Item No. **Report of the Head of Planning, Transportation and Regeneration**

Address CARPENTERS COTTAGE, FORMER RAF UXBRIDGE, ST ANDREWS PARK HILLINGDON ROAD UXBRIDGE

Development: Demolition and replacement of roof, refurbishment and restoration of building including replacement windows and doors, to aid conversion of building to residential dwelling (Listed Building Consent)

LBH Ref Nos: **585/APP/2020/2131**

GROUND FLOOR LAYOUT

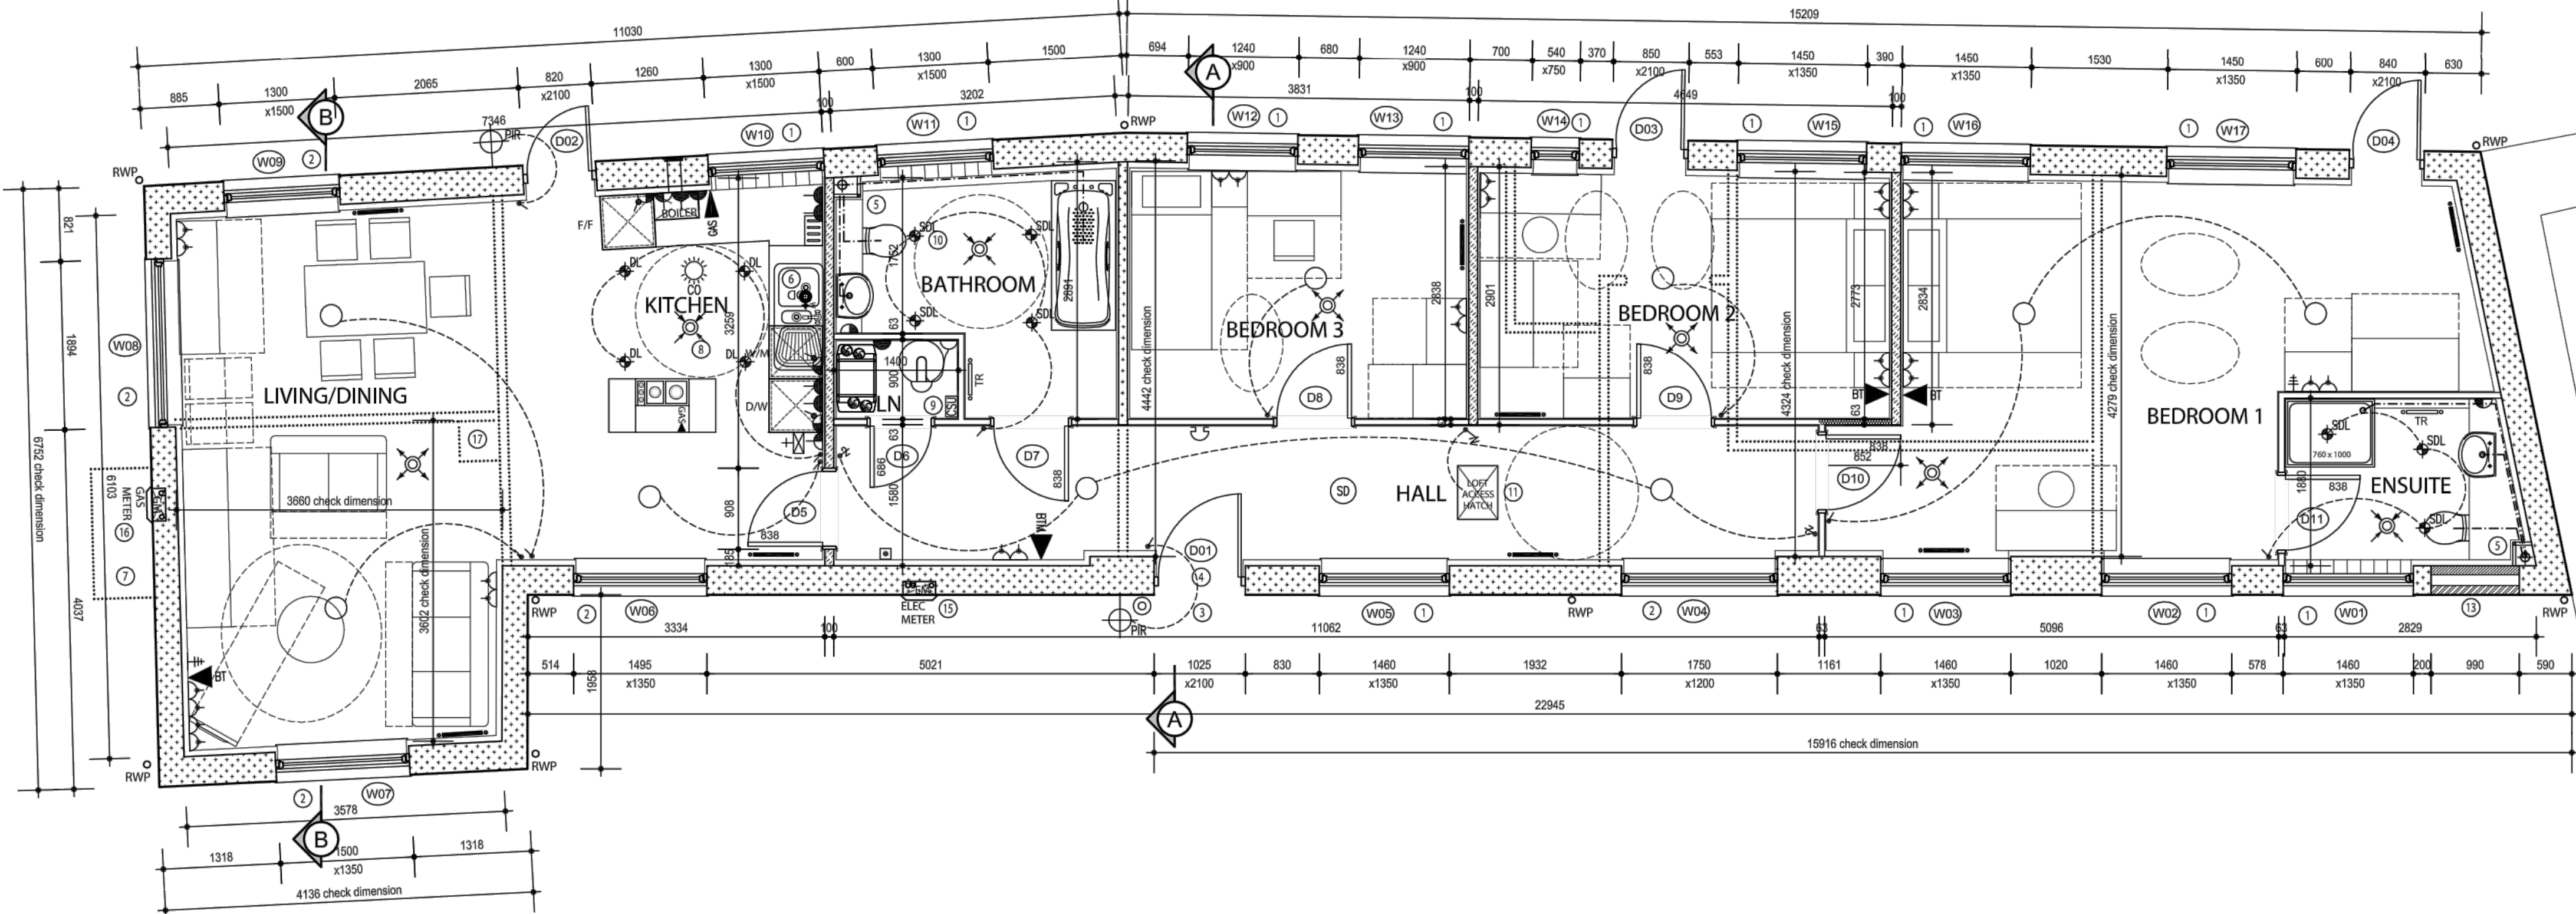
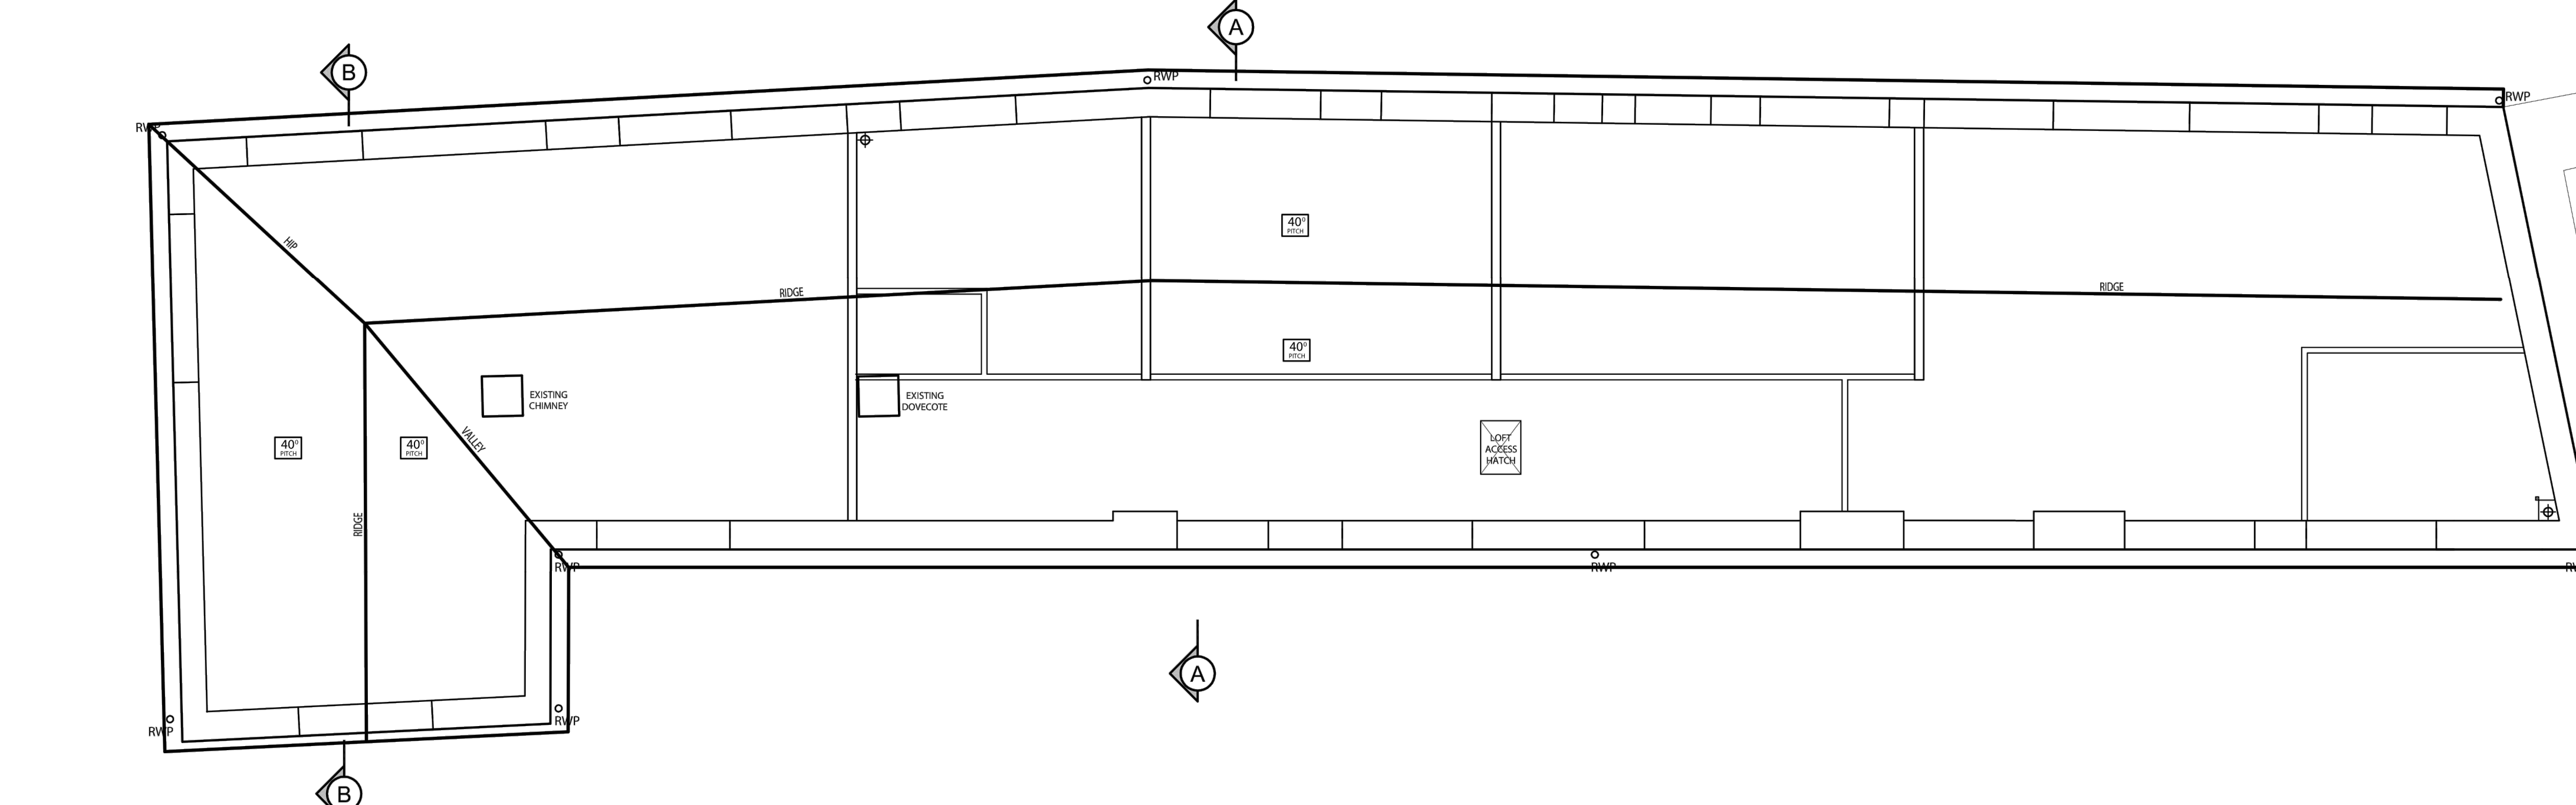
Drawing No 03 appears to differ in terms of layout to drawing Nos 07 and 201, in terms of the location of the en-suite to the master bedroom (southern end of the building) bedroom 3 and the main bathroom and the inclusion of a hall. Clarification on what is being proposed in terms of ground floor plan would be required.

| FORMER RAF UXBRIDGE, ST ANDREWS PARK | 05      | 1:100<br>@ A1 | PROPOSED SITE PLAN | GENERAL ISSUE |  |  |  |  |  | 19.51       |                                                                                                                              |

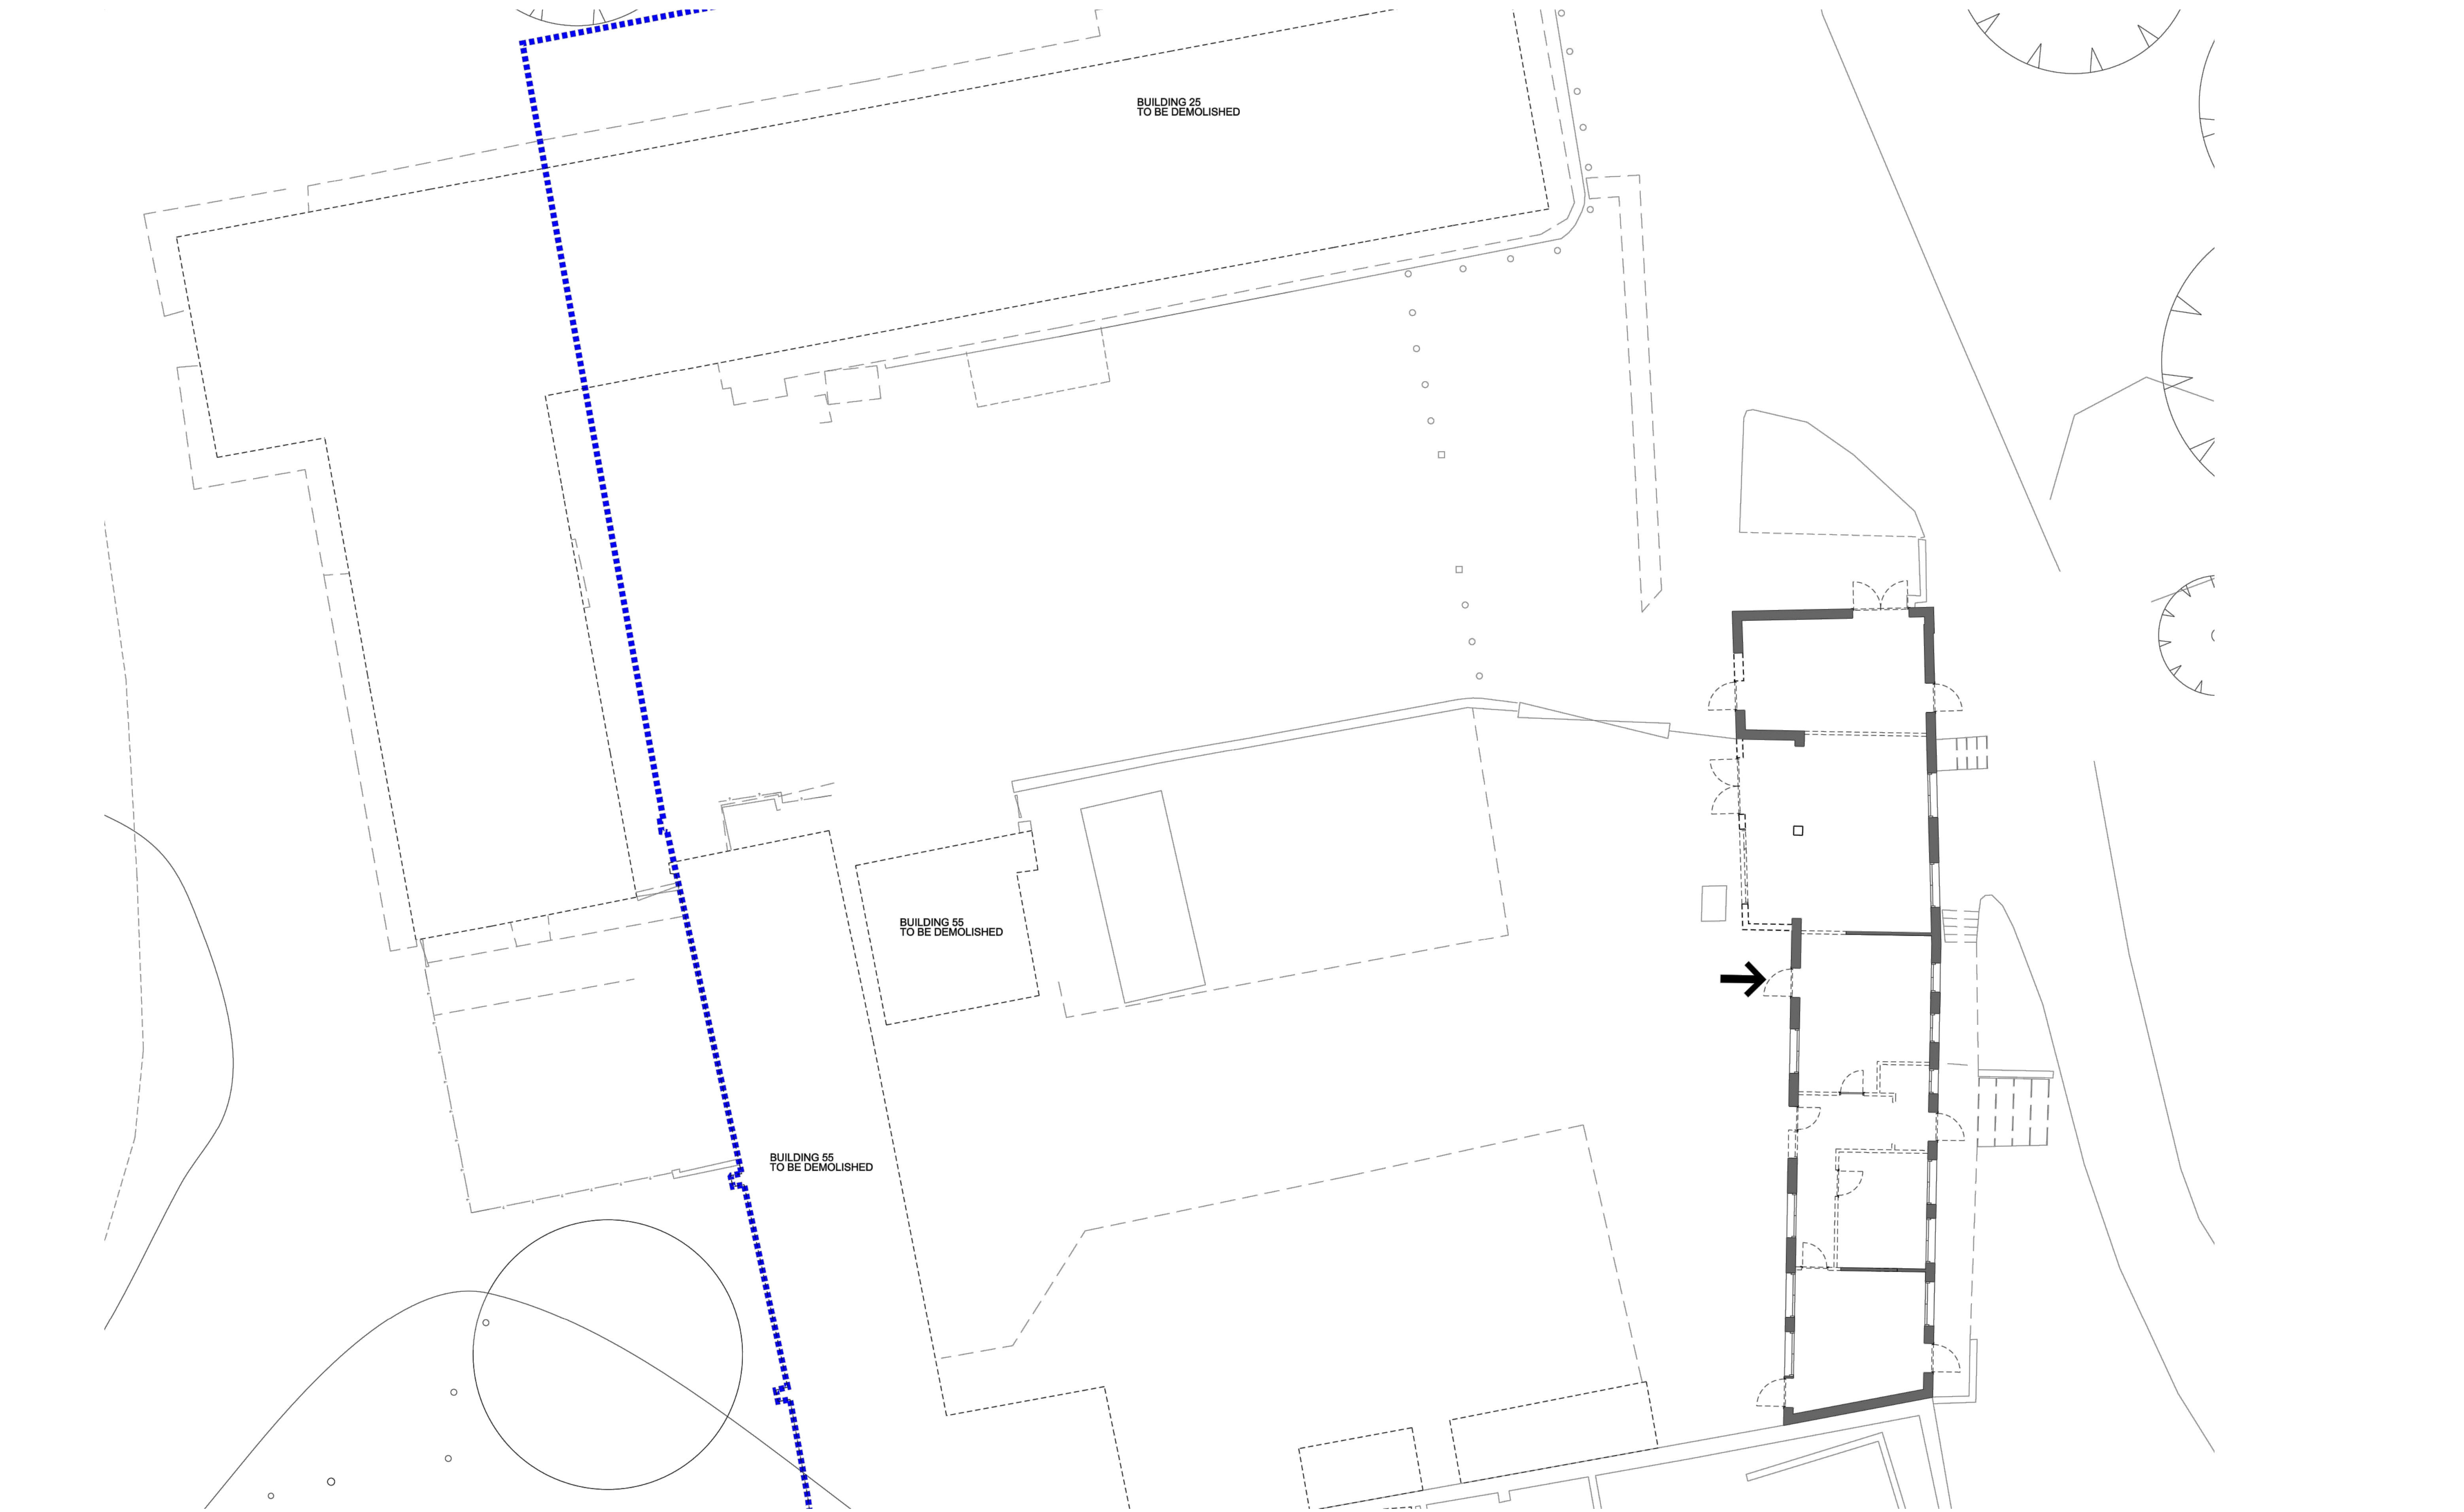
The proposed site plan (dwg No 05) does not accurately depict the existing situation. The previous building have already been demolished and replaced by new properties to the west of the application site, creating what is now known as Newall Close.
